Application Reference: Y/9/25/DOC	Initial Issue Date: 21/02/2025
Site Name: Fleurie Nursery Lake Lane Barnham PO22 0AL	Issue Date:
	Reviewer Reference: ADC/SB

Application Reference:	Y/9/25/DOC	Reviewer Reference:	ADC/SB
Planning Officer:	Amber Willard	Date of Review:	21/02/2025
Site Name:	Fleurie Nursery Lake Lane Barnham PO22 0AL		
Application Description:	Approval of details reserved by condition imposed under reference Y/26/24/PL relating to condition number 4 - surface water drainage scheme, condition number 5 - discharge flows to watercourses, condition number 6 - maintenance and management of the surface water drainage system and condition number 10 - Biodiversity Enhancement Layout.		
Assessment Number:	1 of 2

- Cover Letter Ref C2904 dated 17 December 2024
- C2904-P-201 Rev P1 – Proposed Contributing Area
- C2904-P-101 Rev P3 – Proposed Drainage Strategy
- C2904-P-501 Rev P1 – Proposed Typical Construction Details
- C2904-P-601 Rev P1 – OWC Application Sheet 1
- C2904-P-602 Rev P1 – OWC Application Sheet 2
- Storm Network KCK Attenuation_11.pfd [Fleurie, Lake Lane] dated 12.12.2024

Figure 4: LEMP Todhurst Rife (South West)

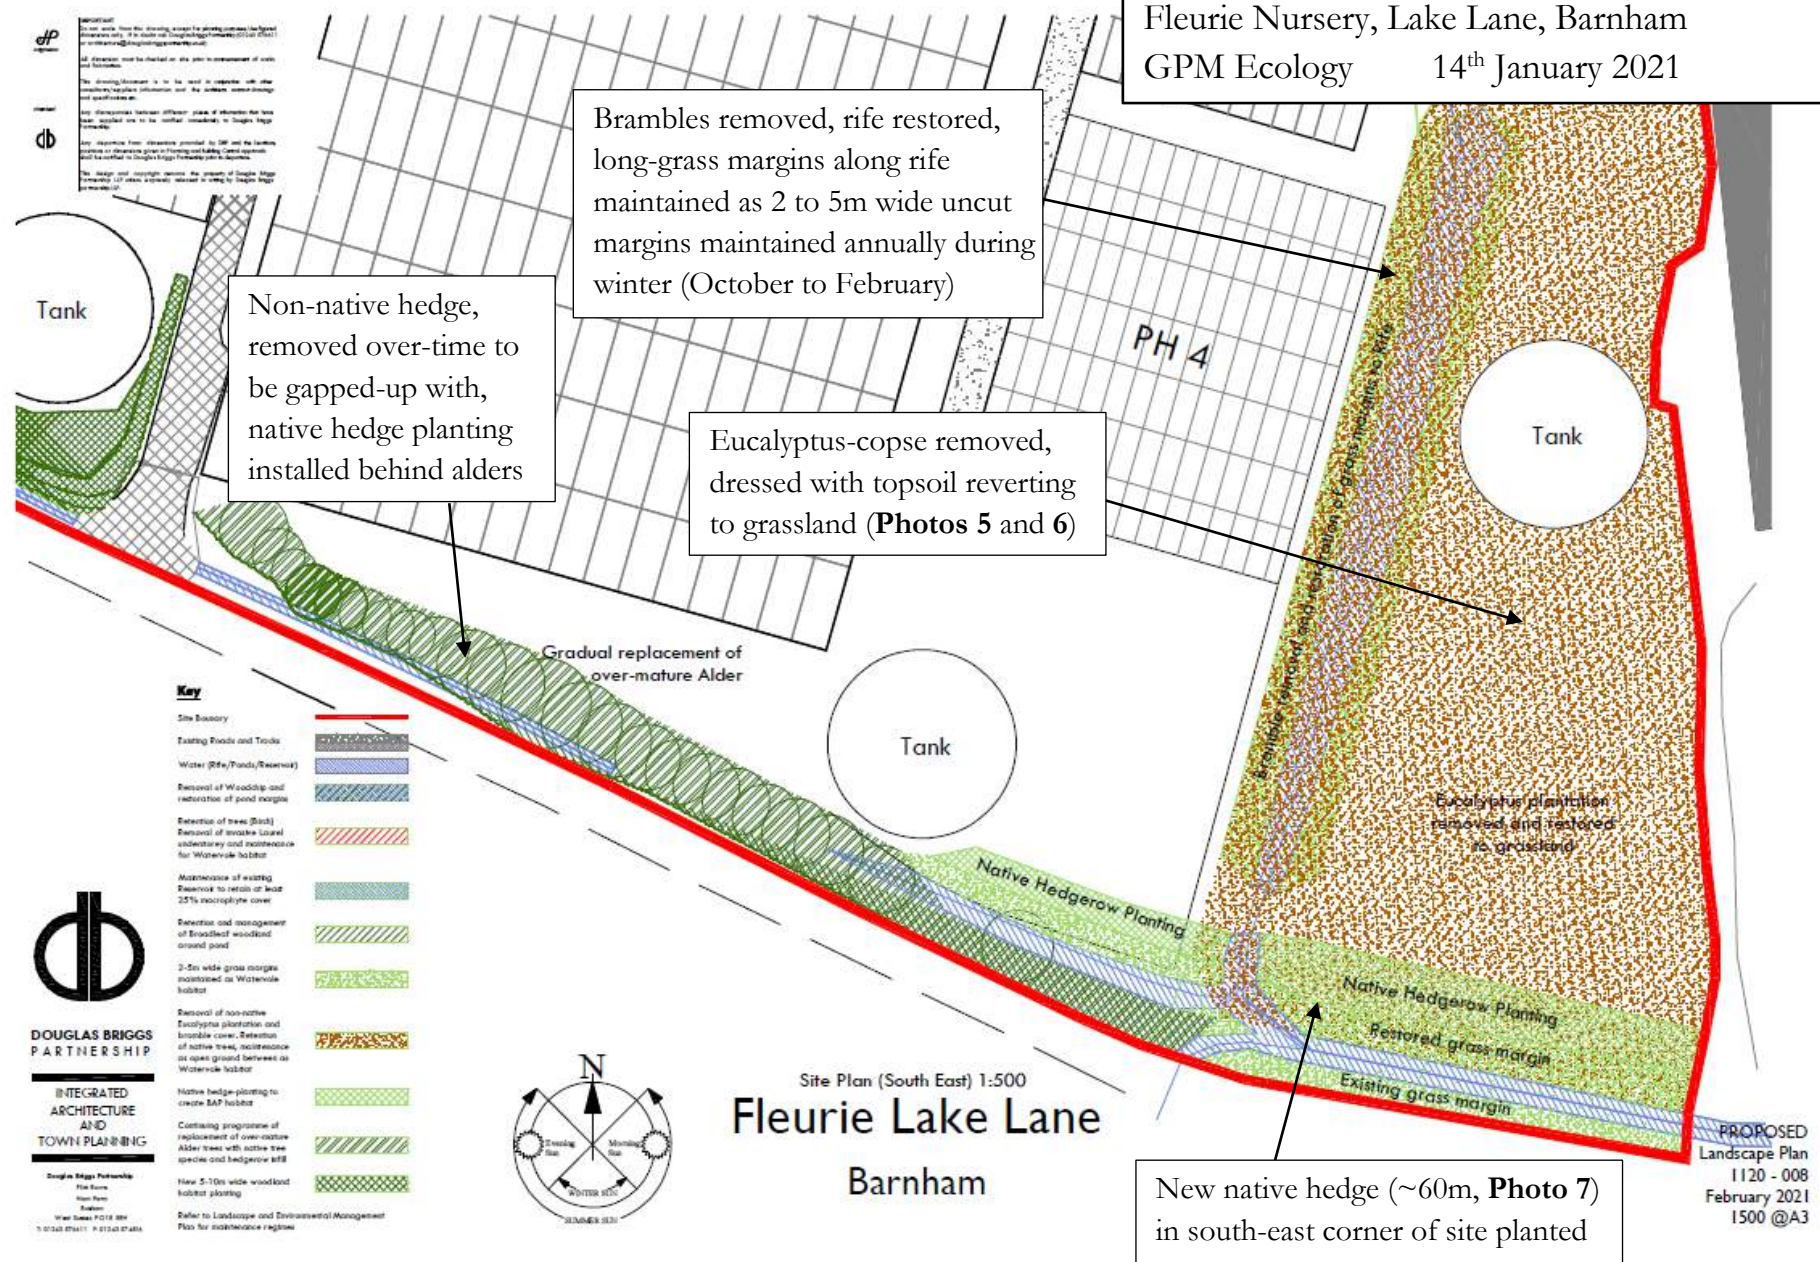
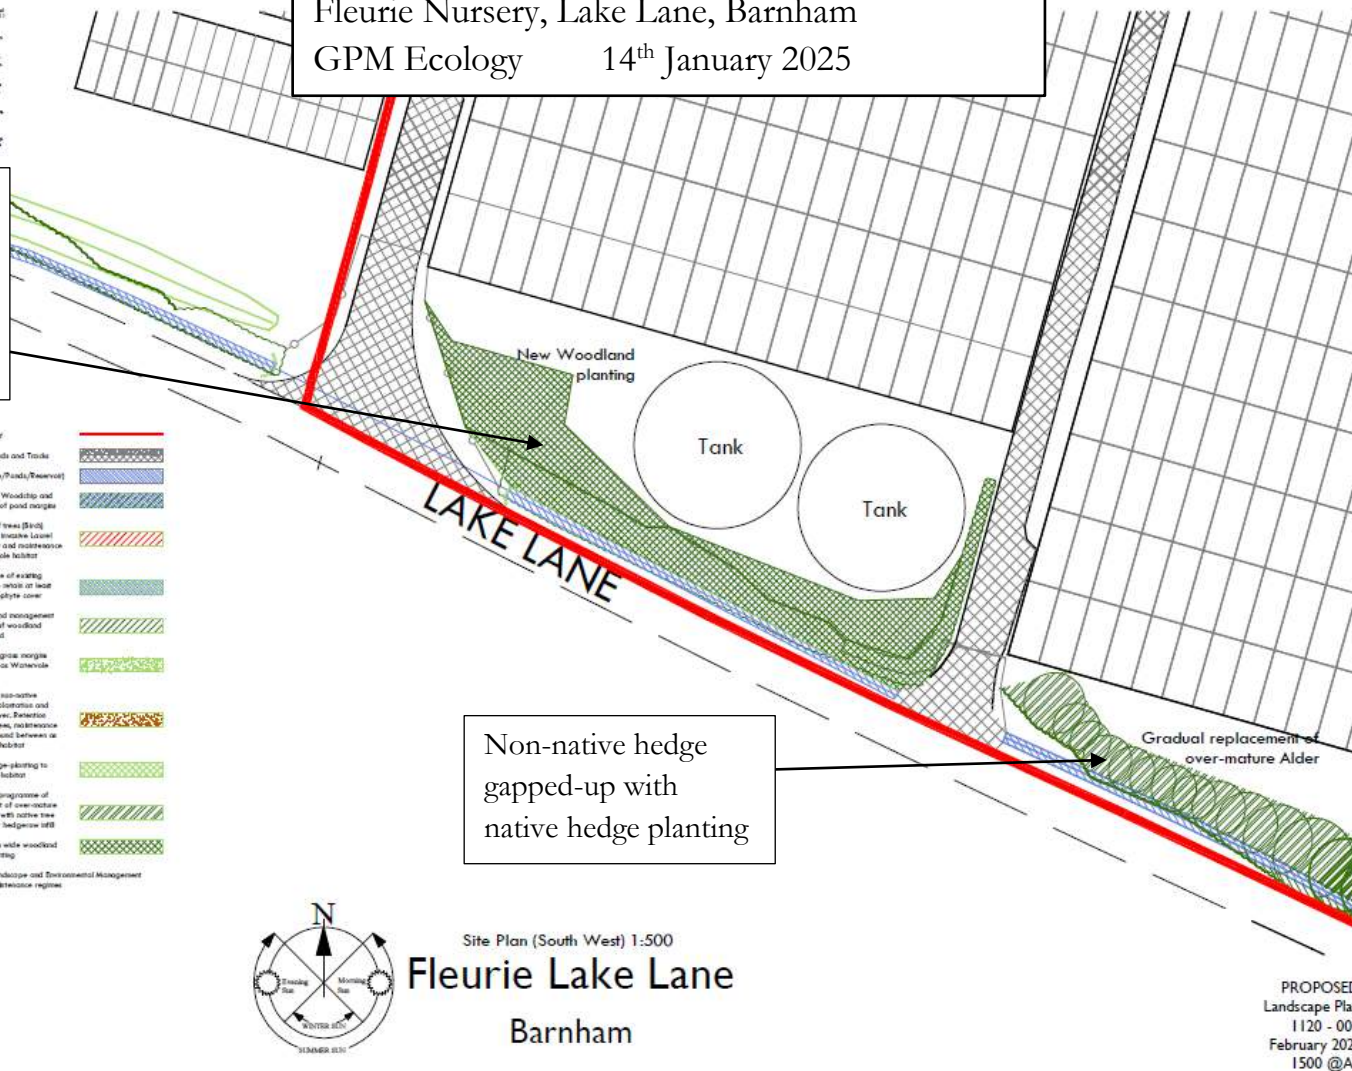
9.	The landscape and ecology management plan refers to a post and rail fence installed post-development to protect the rife. Please clearly demark this fence on the plans and ensure that is not within the easement for the watercourse.

CONTRIBUTING AREA PLAN (1:200)

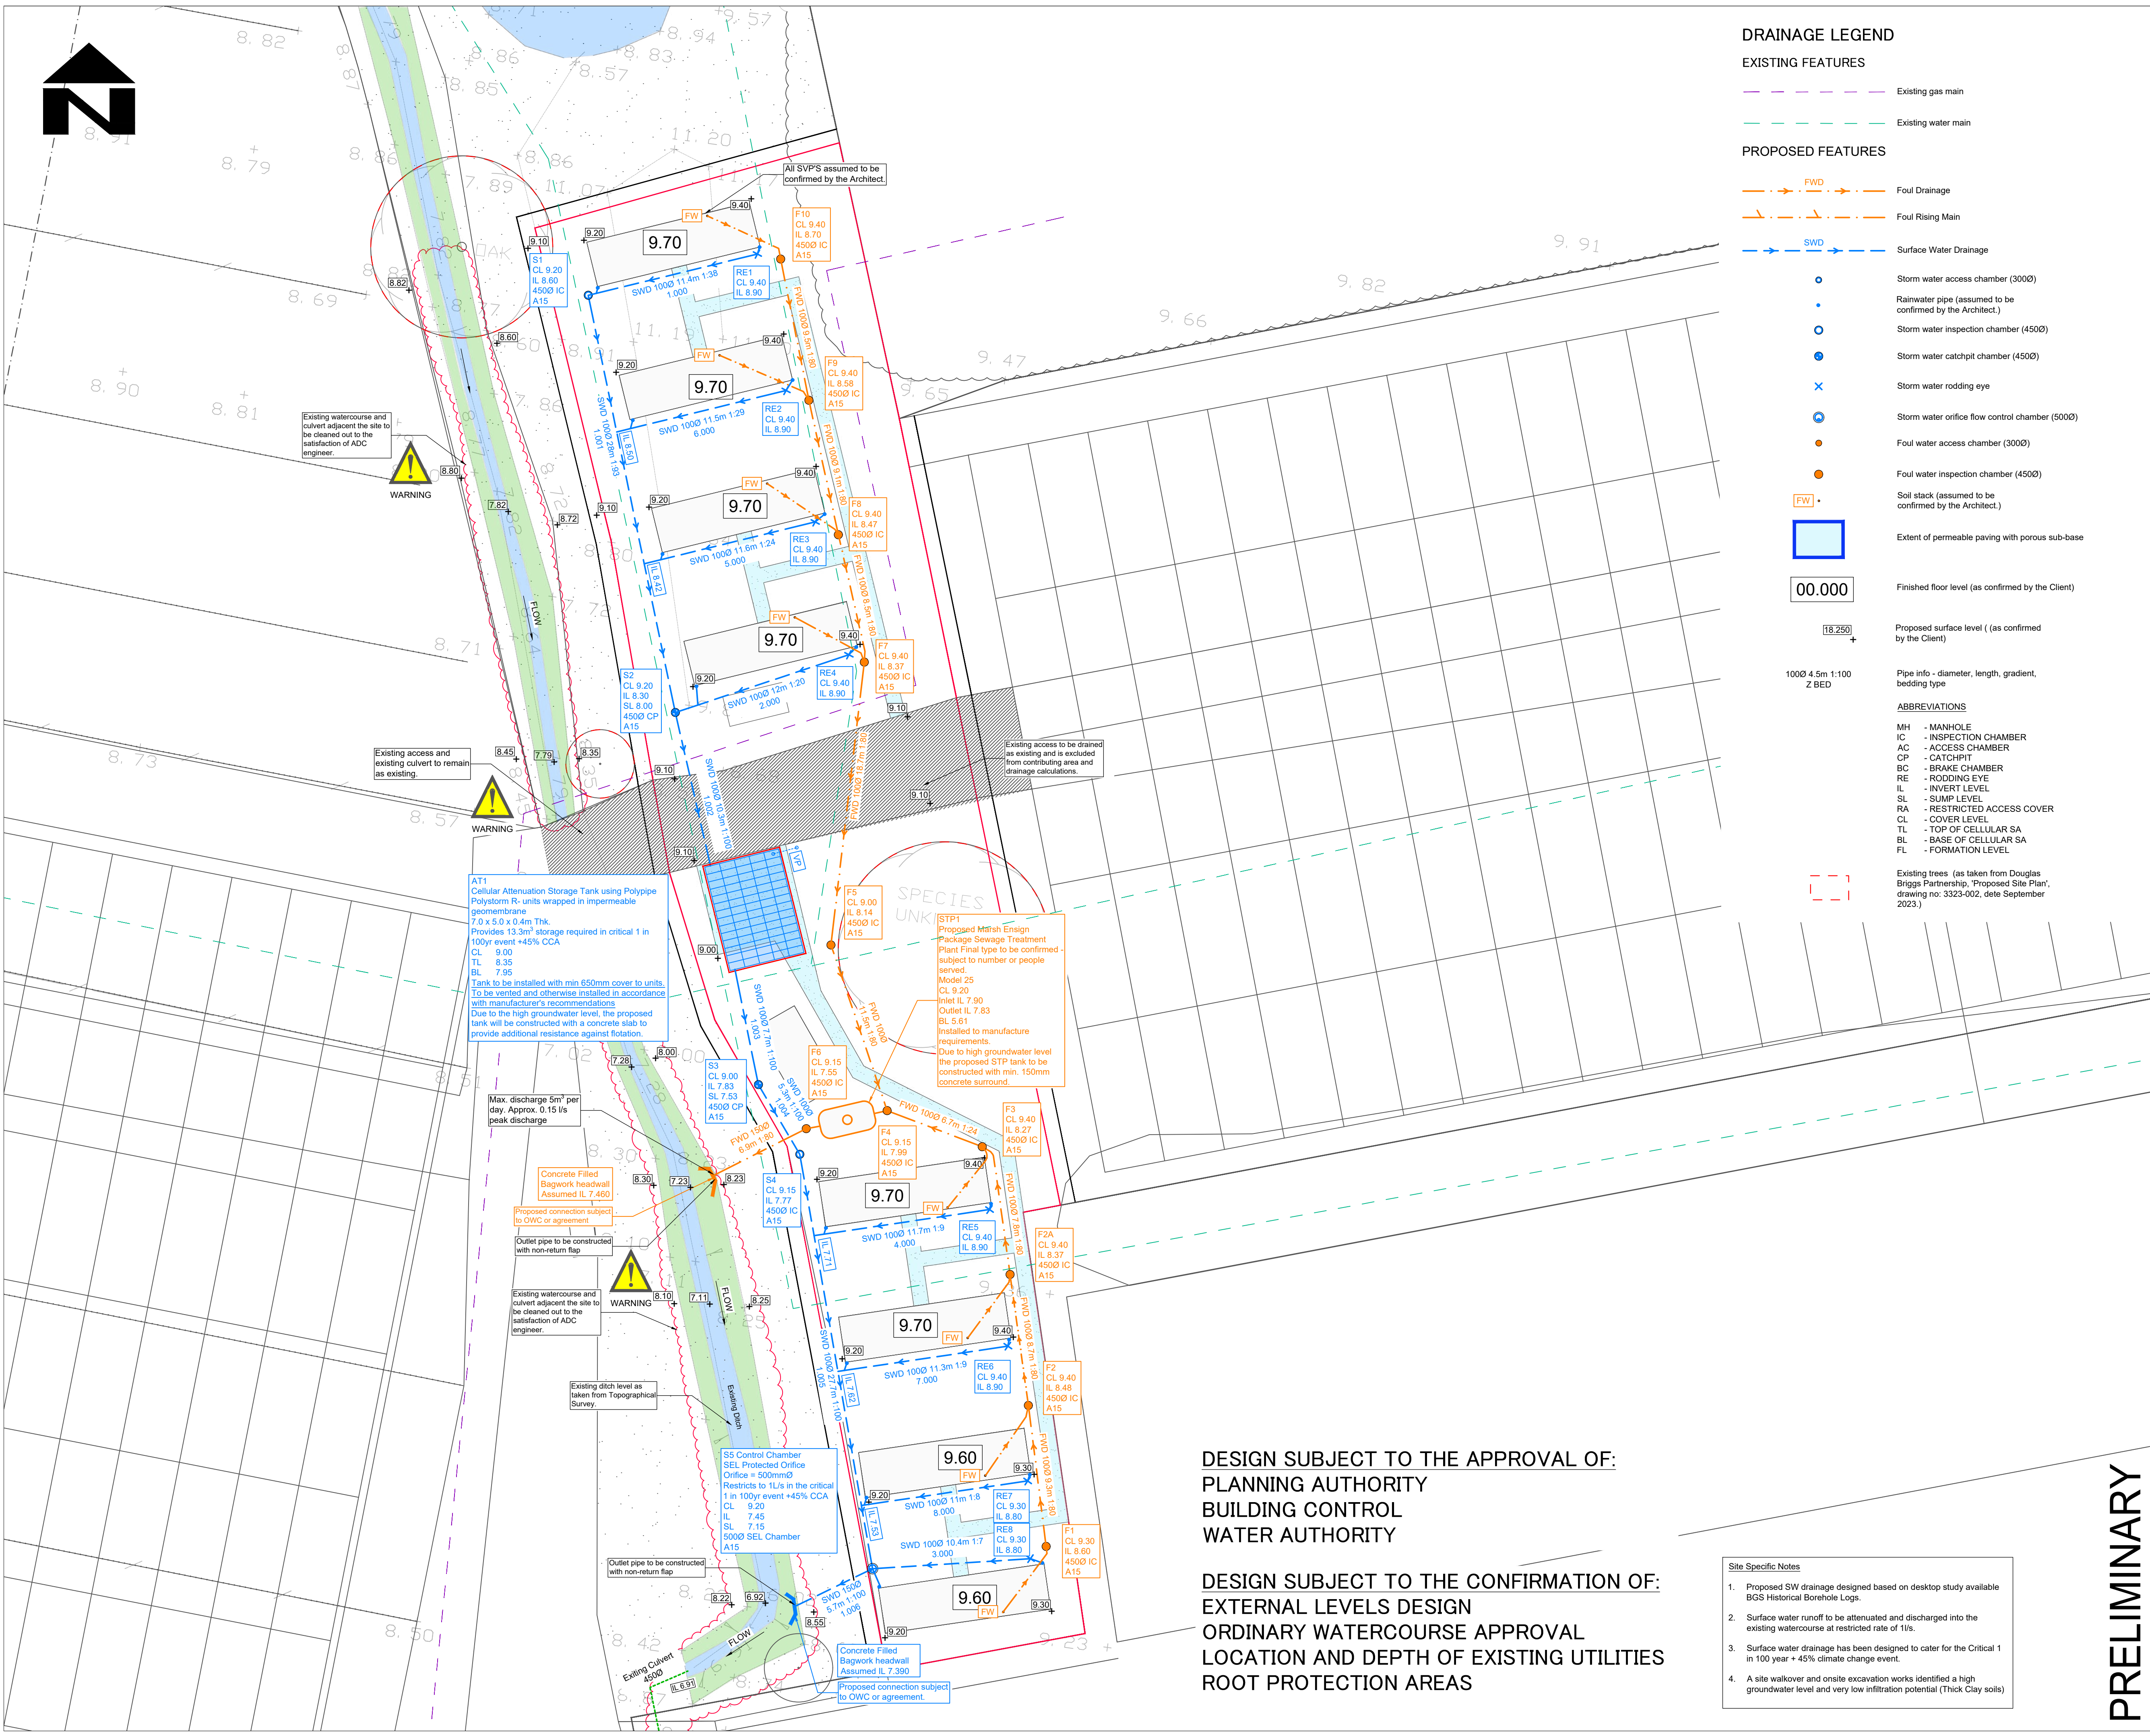
5.	Please correct the impermeable area contributions in the modelling. Currently less than described on the plan due to rounding down. The southern areas are also shown entering the system at S4 which is an inaccurate representation. If grouped together then they should be showing as entering at S5.
